**Our Case Number:** ABP-308210-20

**An  
Bord  
Pleanála**

**Re:** 6 no. wind turbines.

Lackareagh and Garranereagh, Lissarda and Barnadivane (Kneeves) Teerelton, Co Cork,

Date and Time: 04/11/2022 11:32  
 Camera: Canon 5D Mark II  
 Lens: Fixed 50mm  
 Camera Height: 1.7m (AGL)

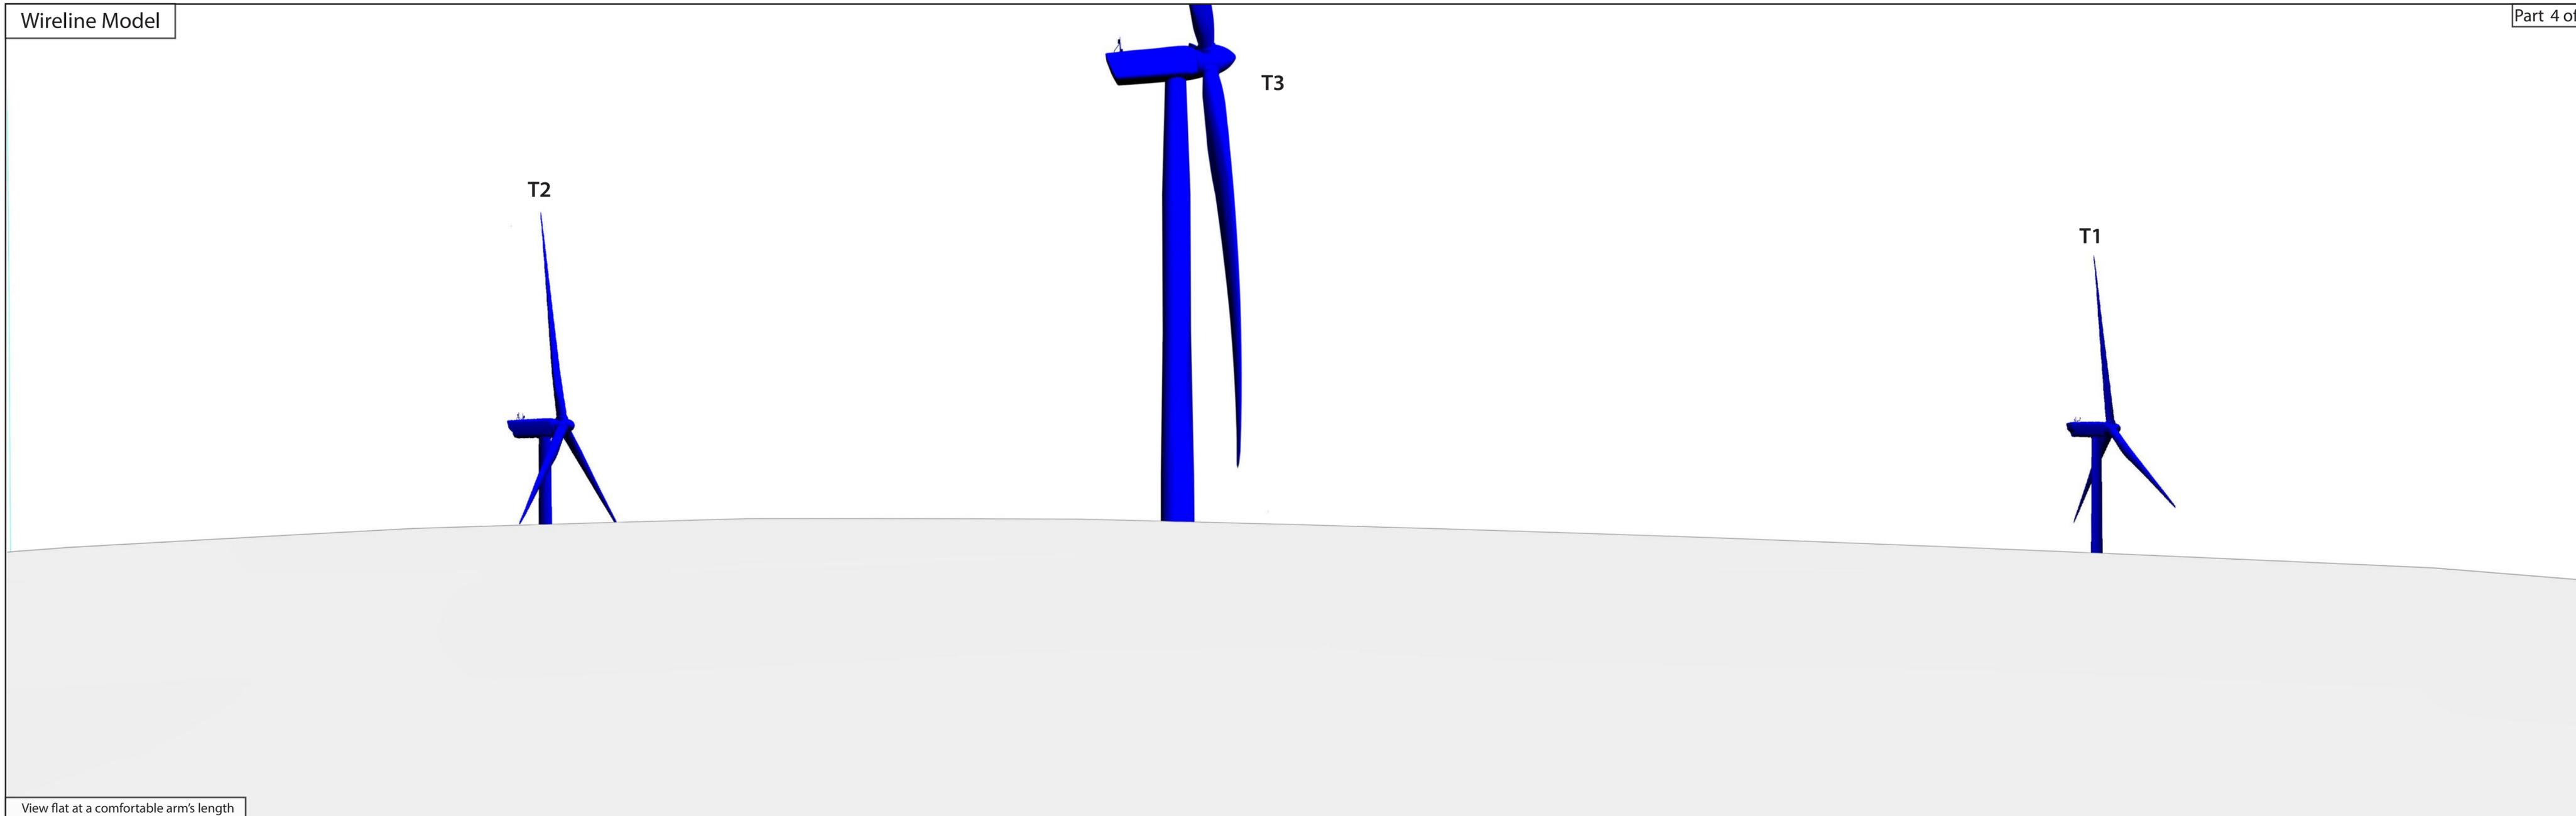
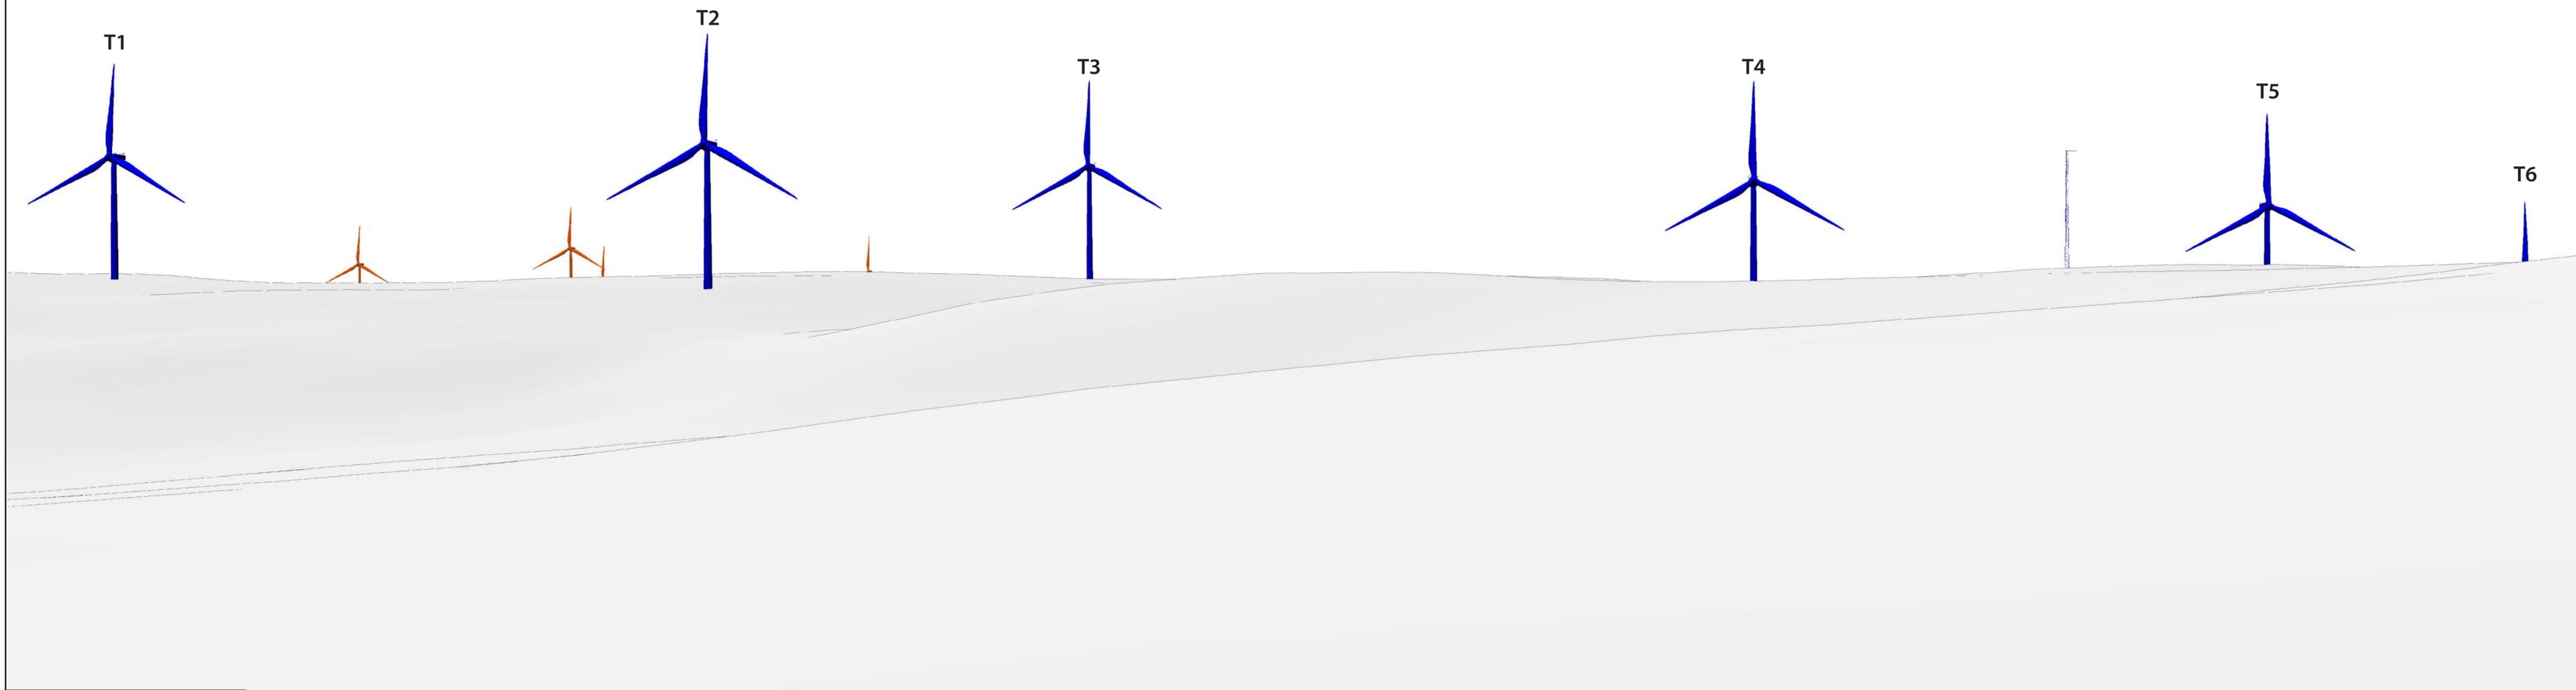
**3. You are requested to review the landscape and visual impact chapter of the EIAR and the accompanying photomontages to ensure that they are up to date and that they provide a robust consideration of cumulative impacts.**
